DE-2017/95

Development	Arts and Social Sciences Building University of Wollongong (SSD 8596)
Location	2 Northfields Avenue, KEIRAVILLE NSW 2500

ATTACHMENT A: COMMENTARY

LANDSCAPE CONCEPT - MASTERPLAN

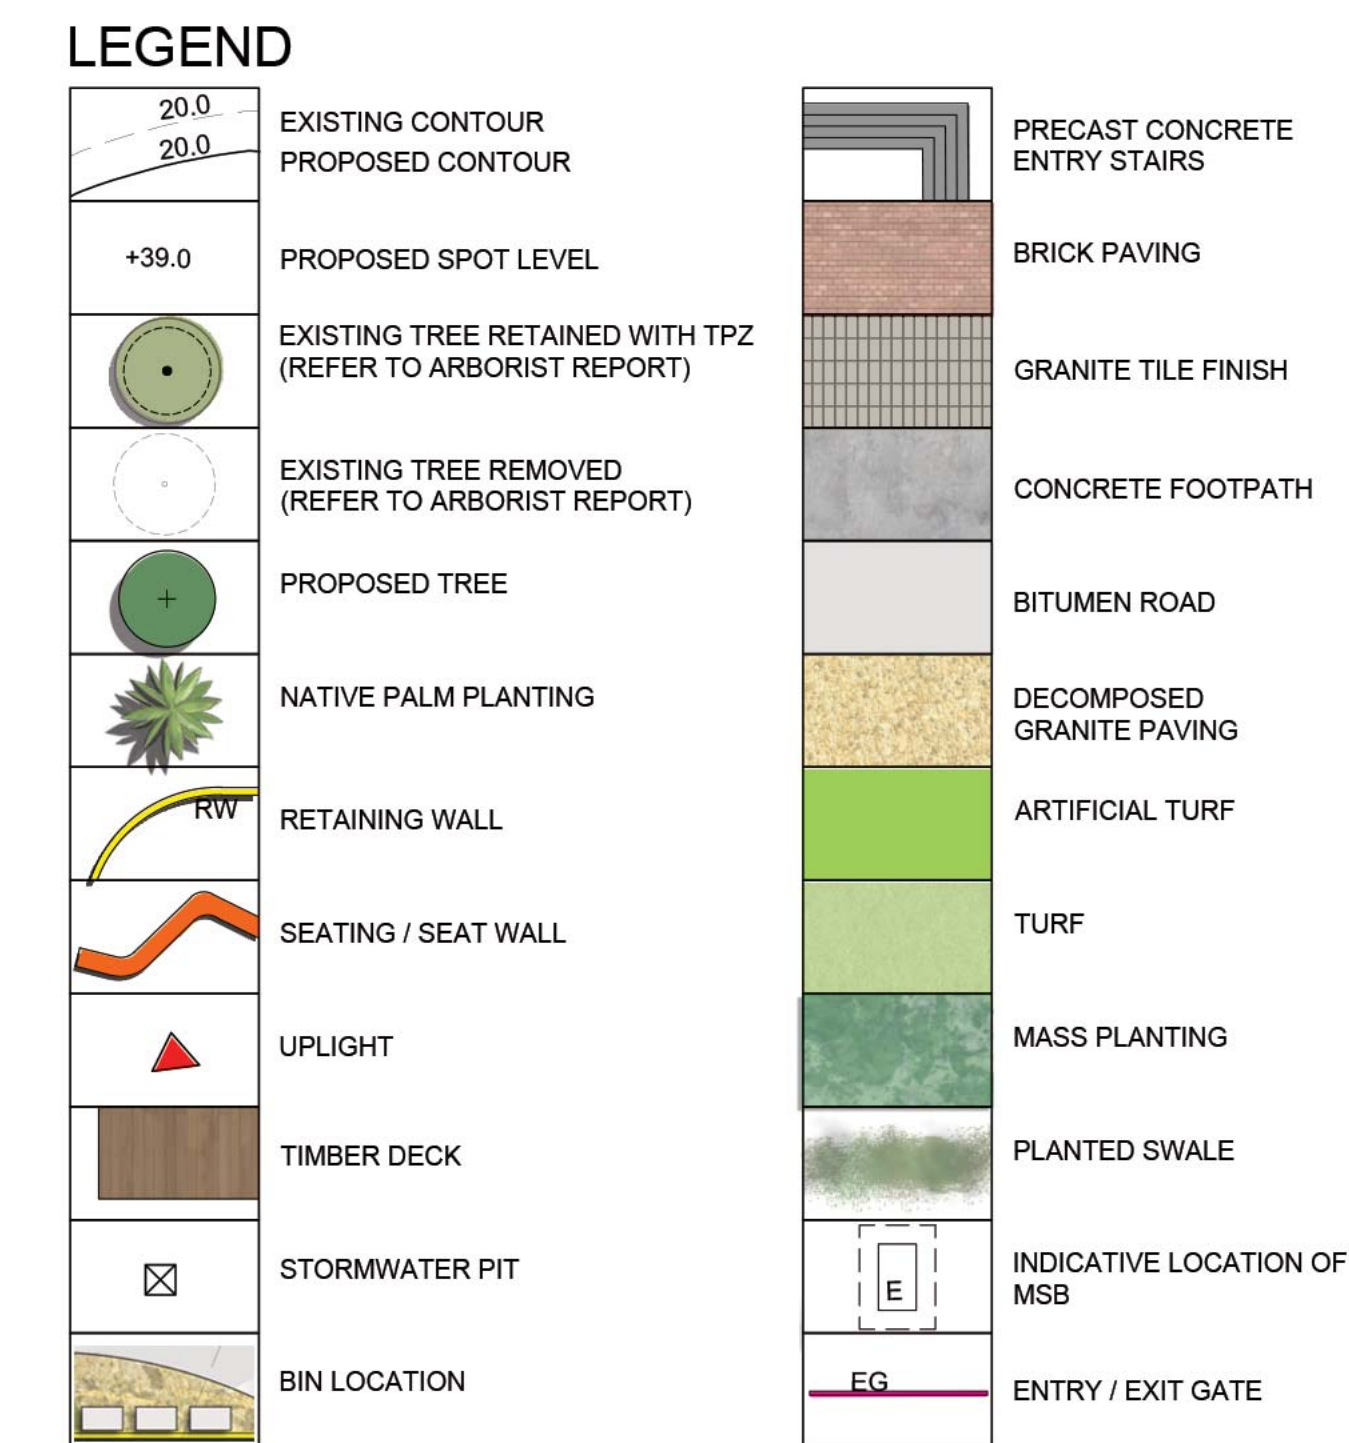
- It is noted that the proposal seeks to retain a small group of the larger trees on site. It is however also noted that over 100 trees, many of them 10m or more in height, are proposed to be removed to accommodate the development.

The removal of these large trees will have a negative impact on the overall amenity and natural environment of the university. The wholesale removal of these trees is not supported in principle.

The developer should retain the existing trees indicated on the Masterplan by Taylor Brammer dated 27 October 2017 consisting of trees numbered 1 – 6, 8 – 43, 45, 46, 48- 59, 61-69, 71-72, 74 – 76, 78-79, 91-102, 104, 105, 107, 111, 115-118, 120-130, 132-138, 149, 152, 155, 158, 201-206 and 229.

The removal of trees numbered 7, 44, 47, 60, 70, 73, 77, 80-90, 103, 106, 108-110, 112-114, 119,131, 139-148, 150, 151, 153, 154, 156, 157 and 159-200 is permitted as indicated on the

Landscape Concept – Masterplan by Taylor Brammer dated 27 October 2017 No other trees should be removed without prior written approval of Council.
